CITY OF ALBUQUERQUE

April 26, 2021

**Re: Bubba's 33
10000 Coors ByPass NW
Traffic Circulation Layout
Engineer's Stamp 04-14-21 (B14-D004H)**

**ACCESSIBLE PARKING STALL DETAIL**

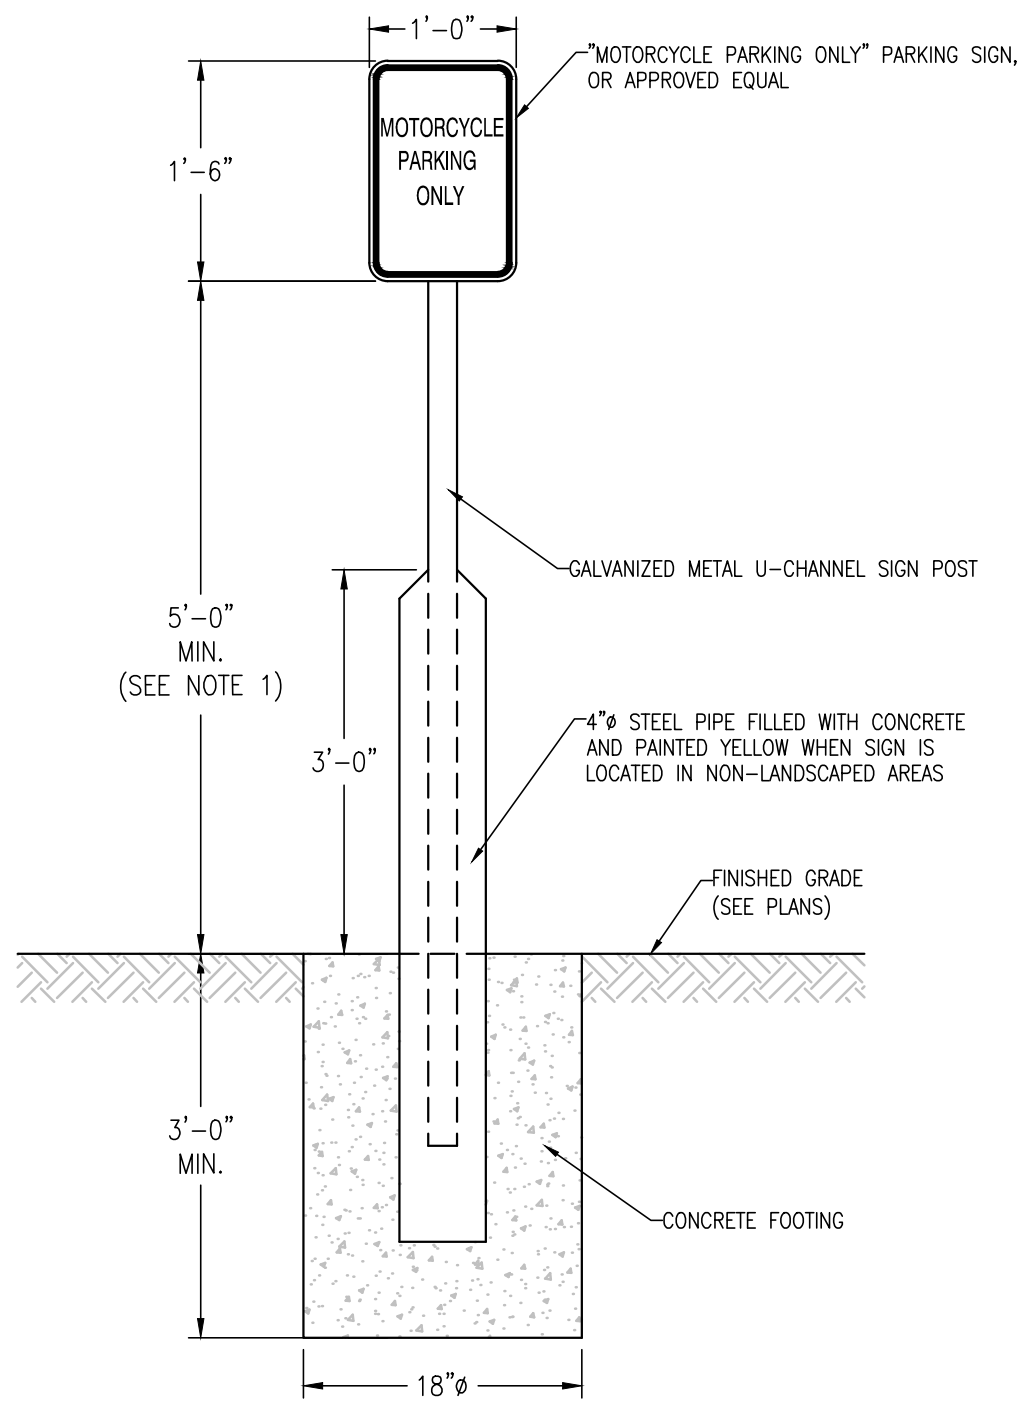
4. **Prior comment not addressed (since a new detail sheet was not provide I went by old detail sheet which doesn't show the phrase and the NO Parking symbol):**

- The ADA accessible parking sign must have the required language per 66-7-352.4C NMSA 1978 **"Violators Are Subject to a Fine and/or Towing."** Please call out detail and location of signs.

- The ADA access aisles shall have the words **"NO PARKING"** in capital letters, each of which shall be at least one foot high and at least two inches wide, placed at the rear of the parking space so as to be close to where an adjacent vehicle's rear tire would be placed. (66-1-4.1.B NMSA 1978) .

BIKE RACK DETAIL
NOT TO SCALE

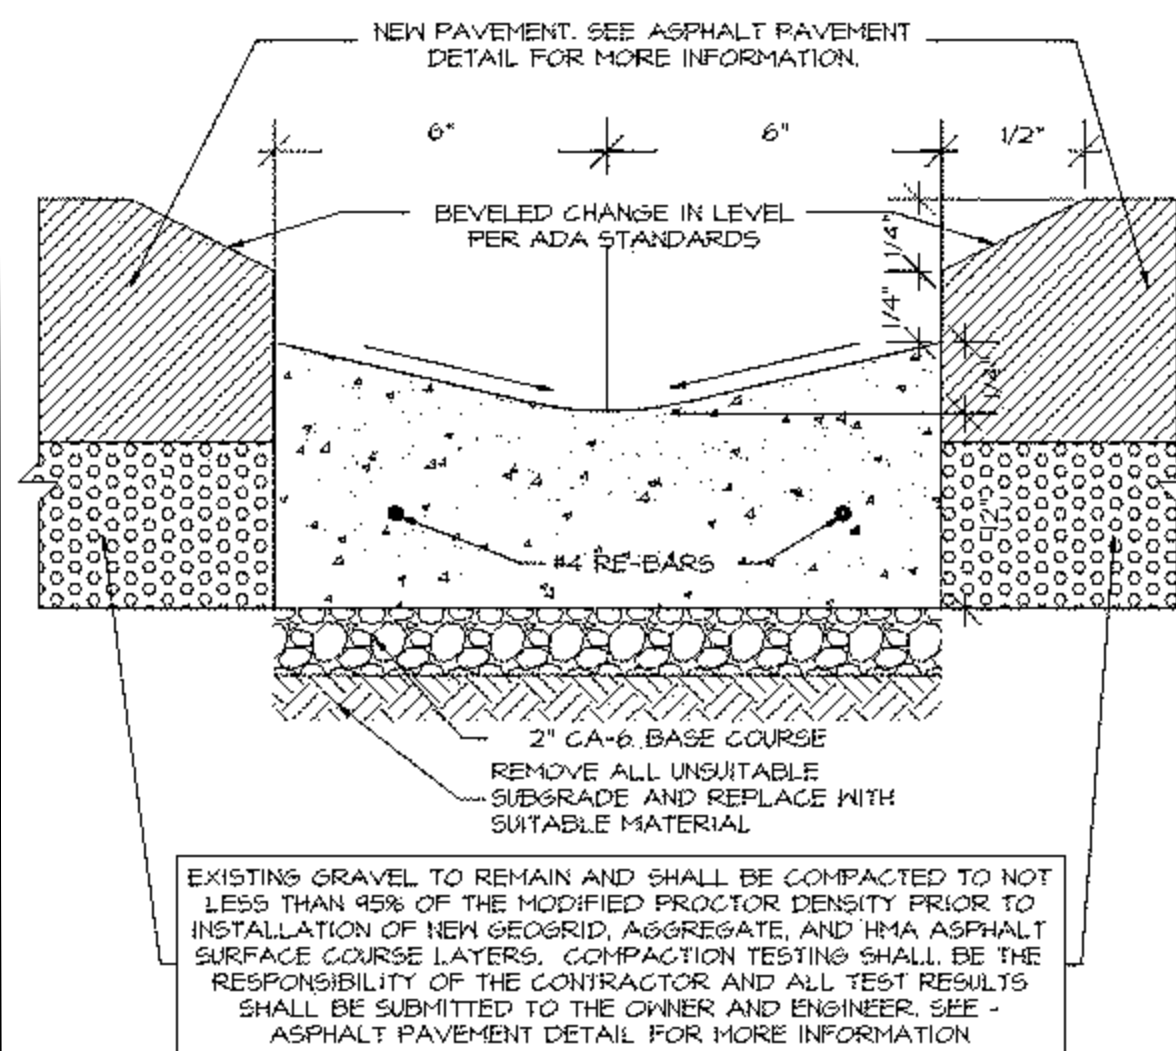
6. **Since no new detail sheets(Sht C7.2) have been provide the comments for bike infrastructure are still applicable:**

7. All bicycle racks shall be designed according to the following guidelines:
 - a. The rack shall be a minimum 30 inches tall and 18 inches wide.
 - b. The bicycle frame shall be supported horizontally at two or more places. Comb/toaster racks are not allowed.

- c. The rack shall be designed to support the bicycle in an upright position. See the IDO for additional information.
 - d. The rack allows varying bicycle frame sizes and styles to be attached.

- e. The user is not required to lift the bicycle onto the bicycle rack.
 - f. Each bicycle parking space is accessible without moving another bicycle.

8. Bicycle racks shall be sturdy and anchored to a concrete pad.
9. A 1-foot clear zone around the bicycle parking stall shall be provided.
10. Bicycle parking spaces shall be at least 6 feet long and 2 feet wide.
